# CITY OF ALBUQUERQUE

**Re: Lot 10 Block 9 Unit 22 Volcano Cliffs, S.A.D. 228  
6401 Petirrojo Rd. NW  
Request Permanent C.O. – Not Accepted Q/O  
Engineer's Stamp dated: 4-11-17 (D10D003121)  
Certification dated: 10/21/17**

CANDELARIA - COMPOS - GRADING & DRAINAGE PLAN

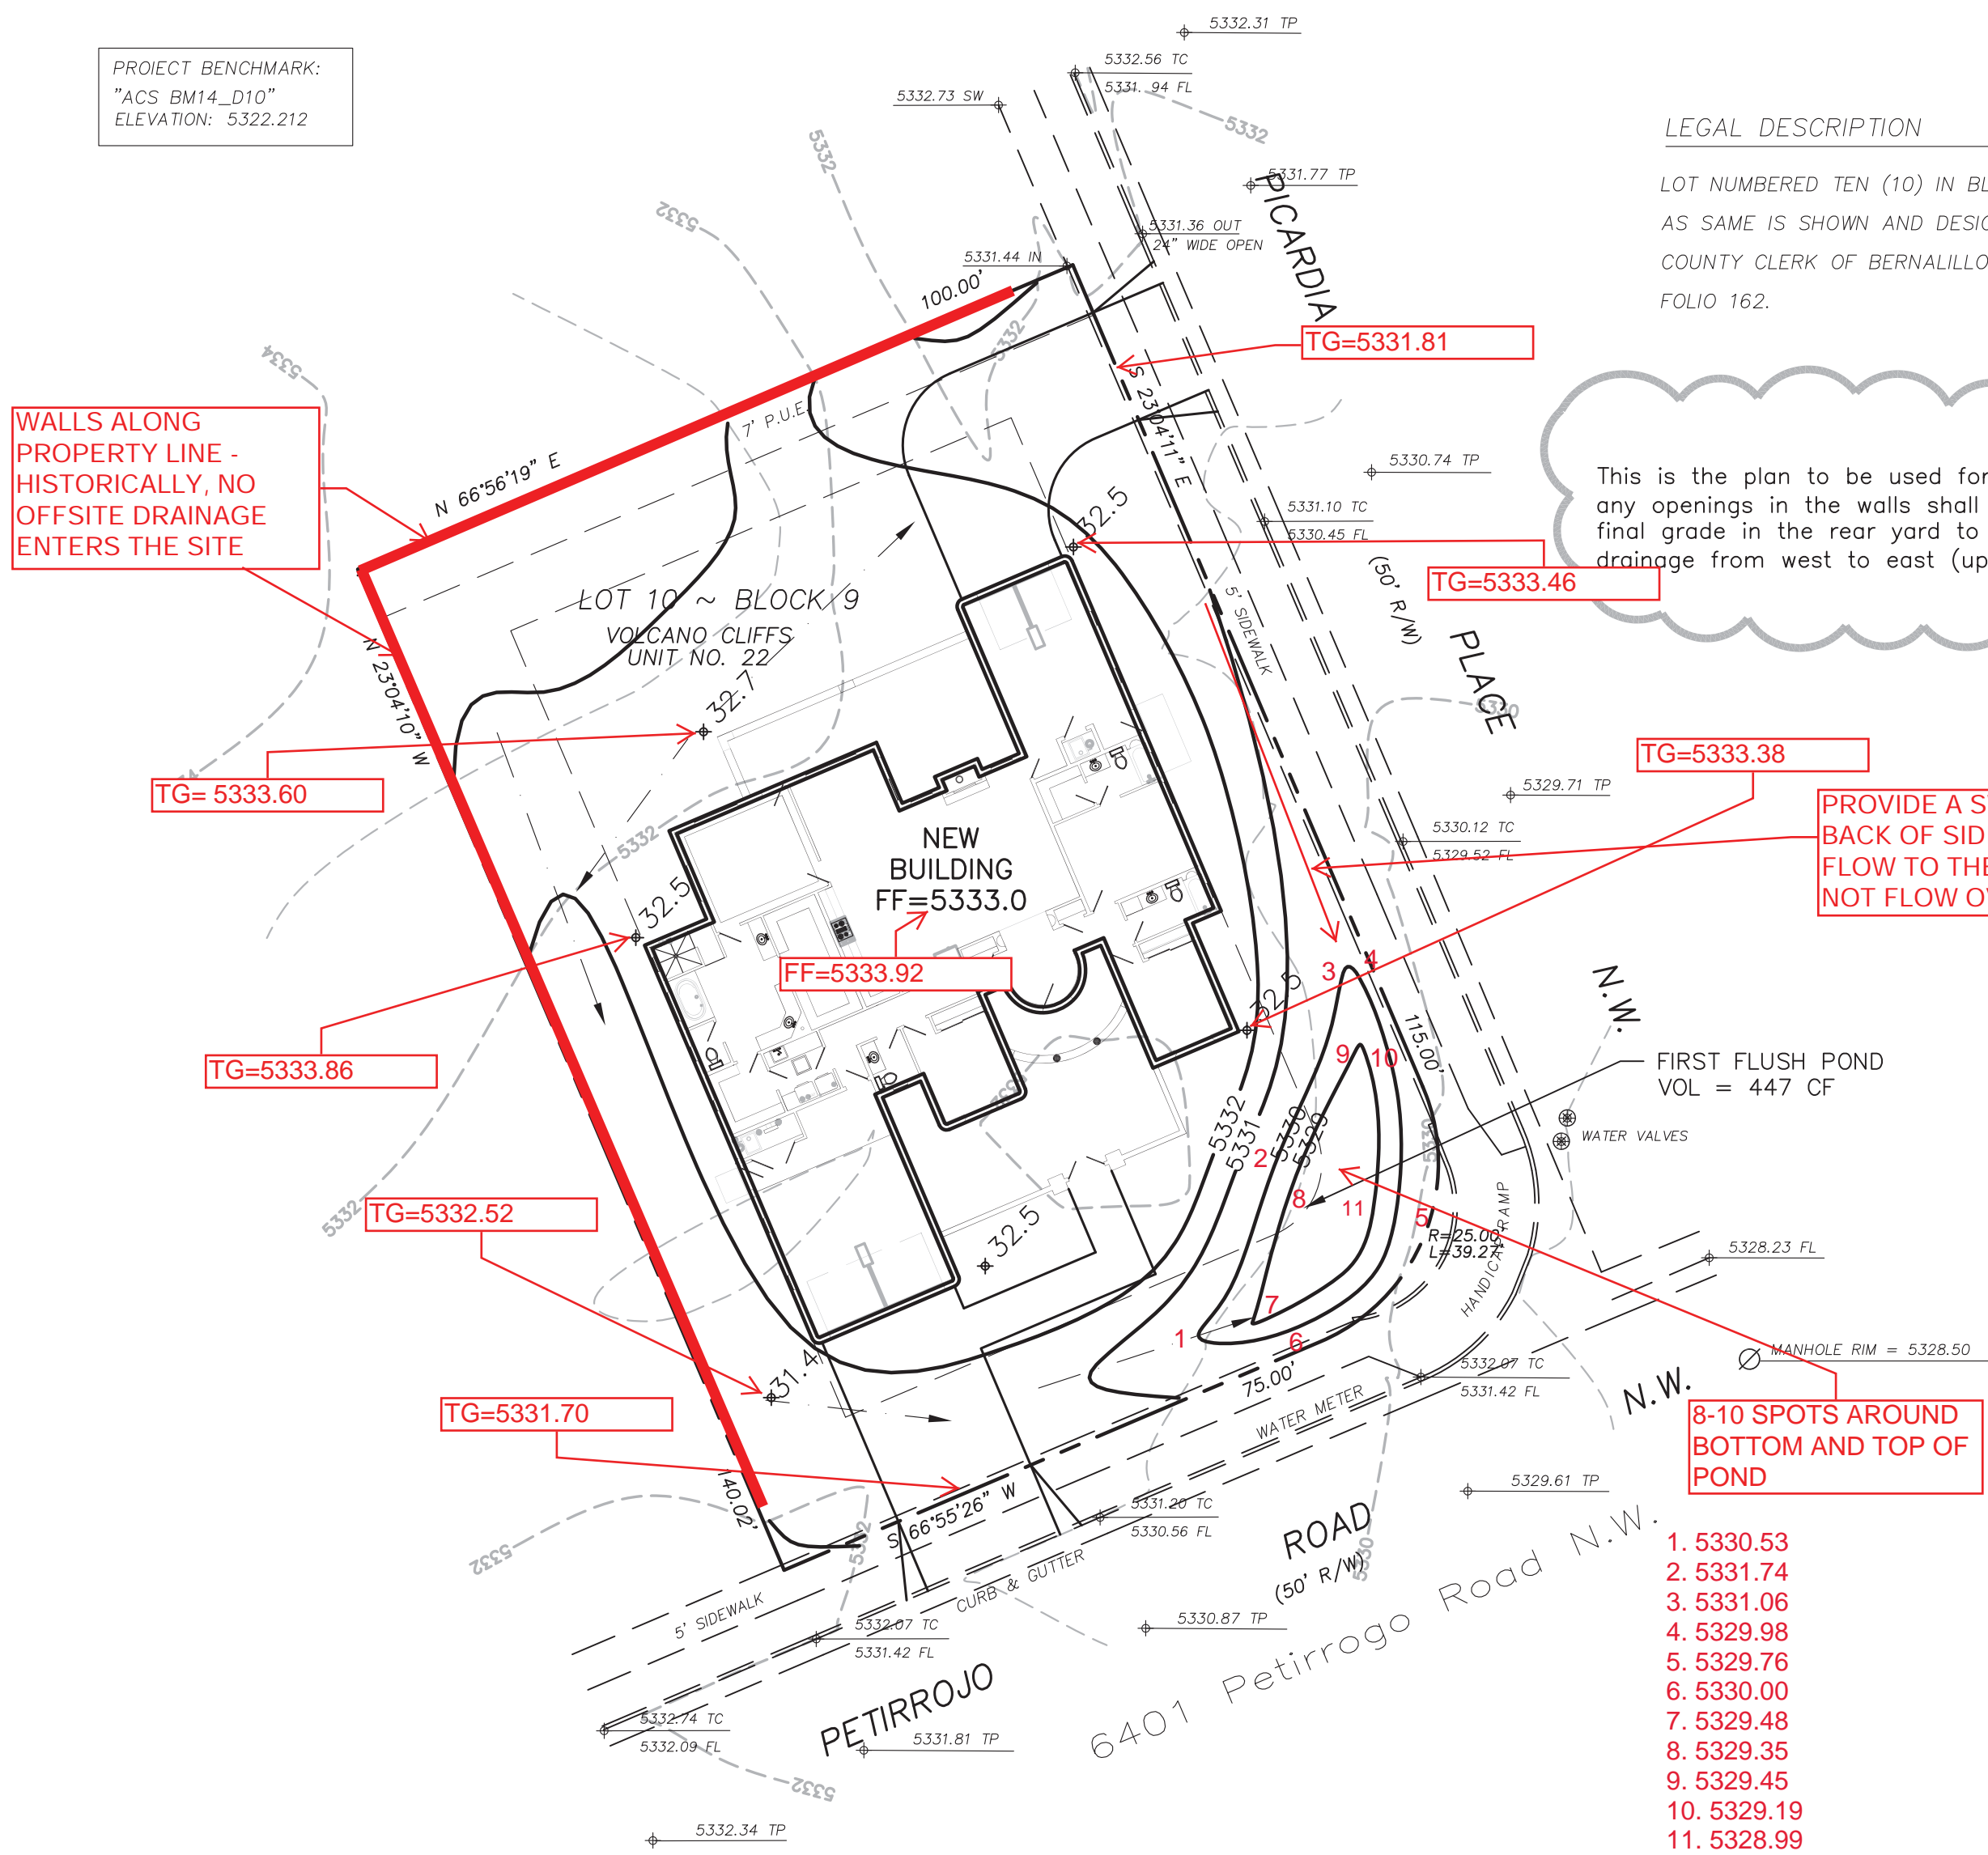
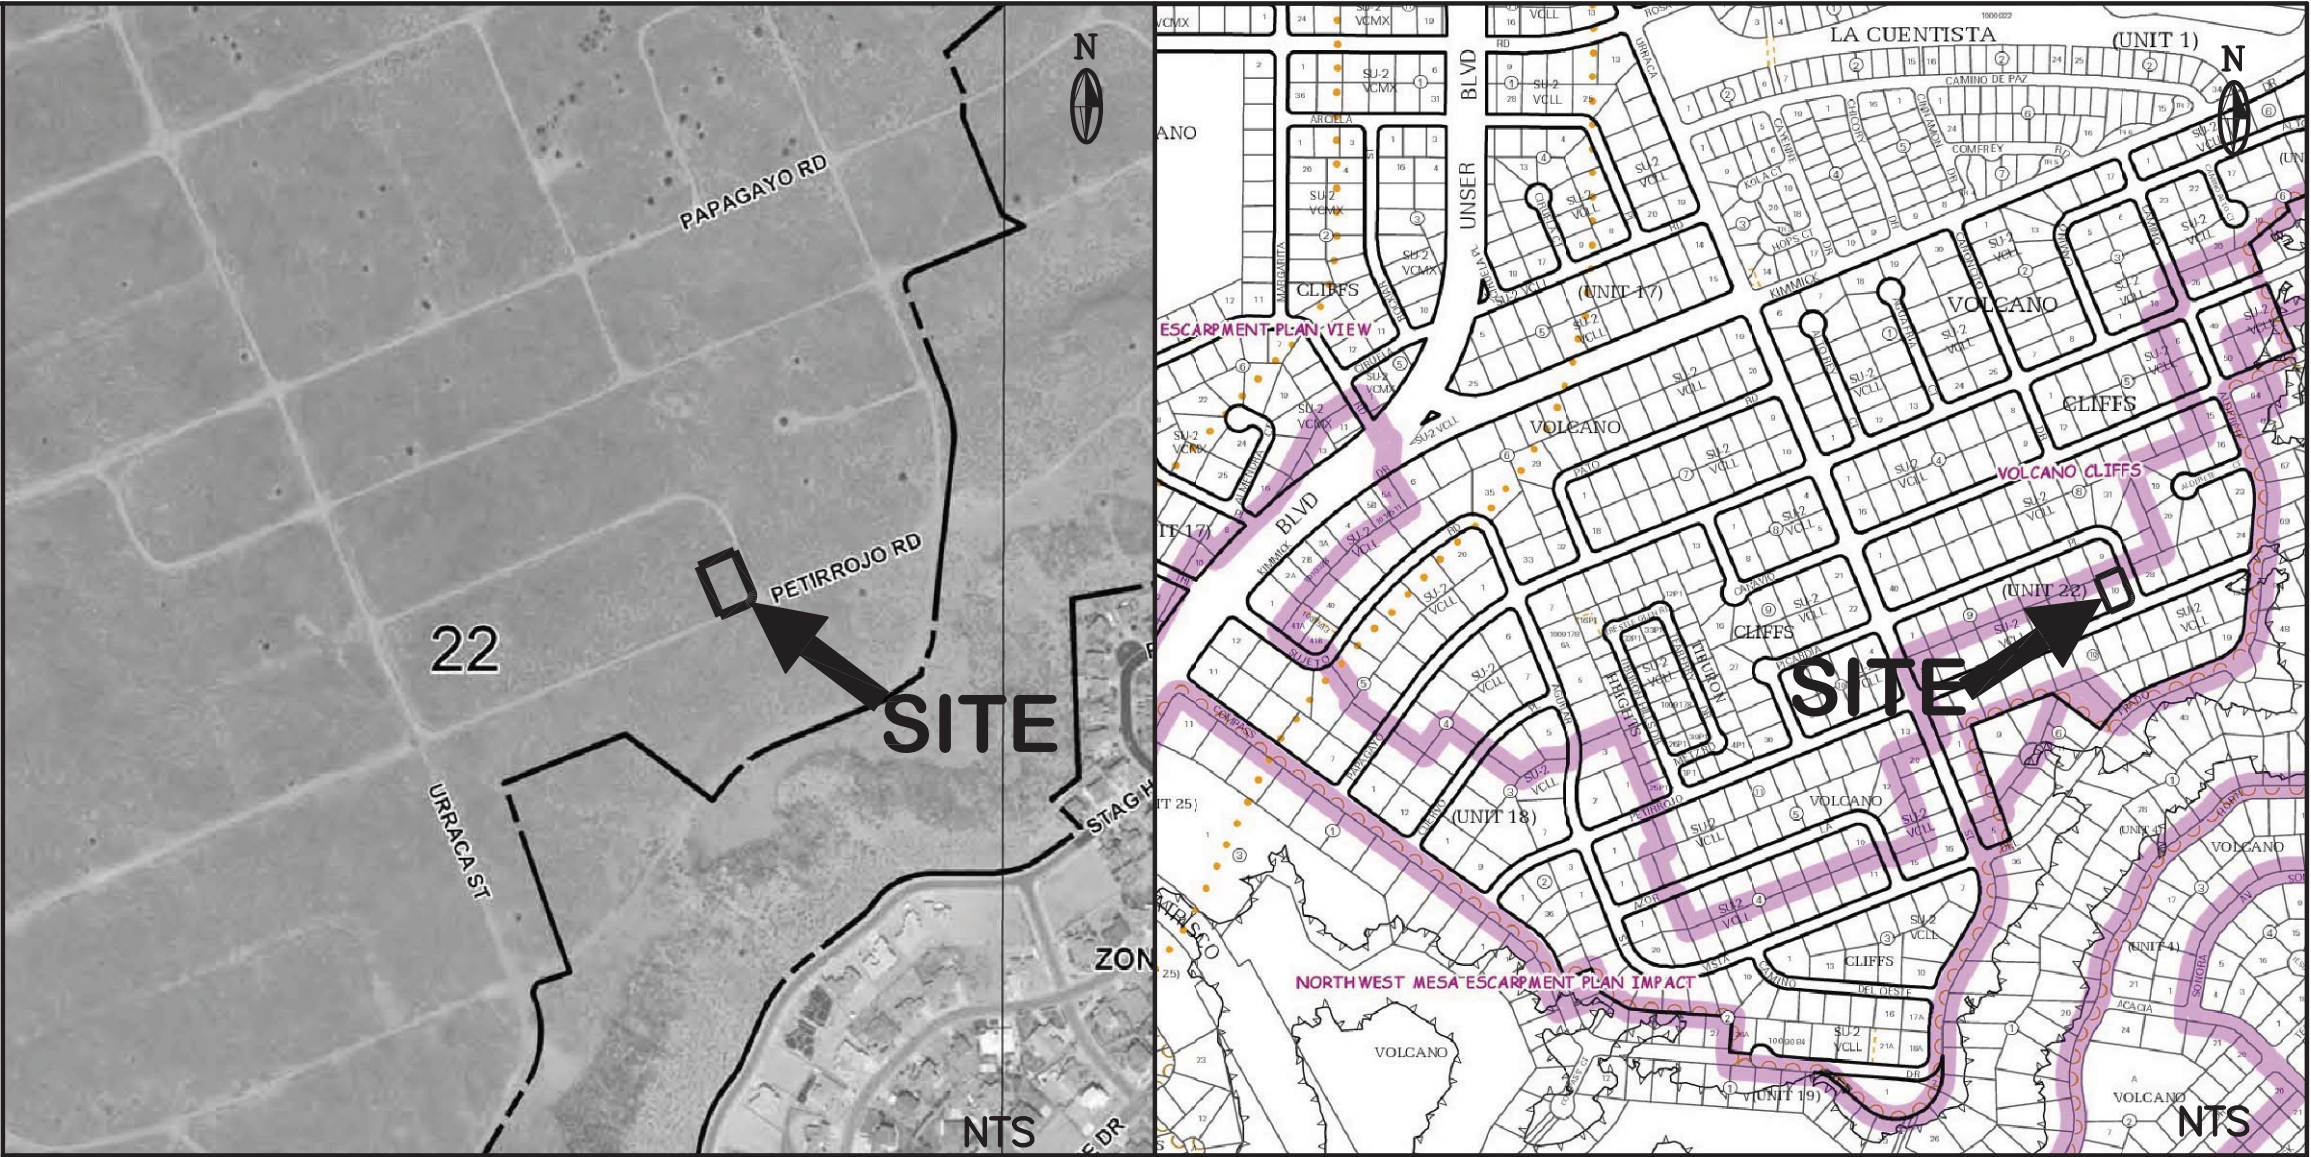
- The garden wall was built without a permit and the approved G&D plan was not submitted.
- The area surrounding the site is not clear of debris and trash. This area must be clean and not contain any leftover materials for proper drainage.
- The east side yard appears to allow flows to exit over the side walk before entering the water quality pond.
- Remove the trash bin in the rear yard.
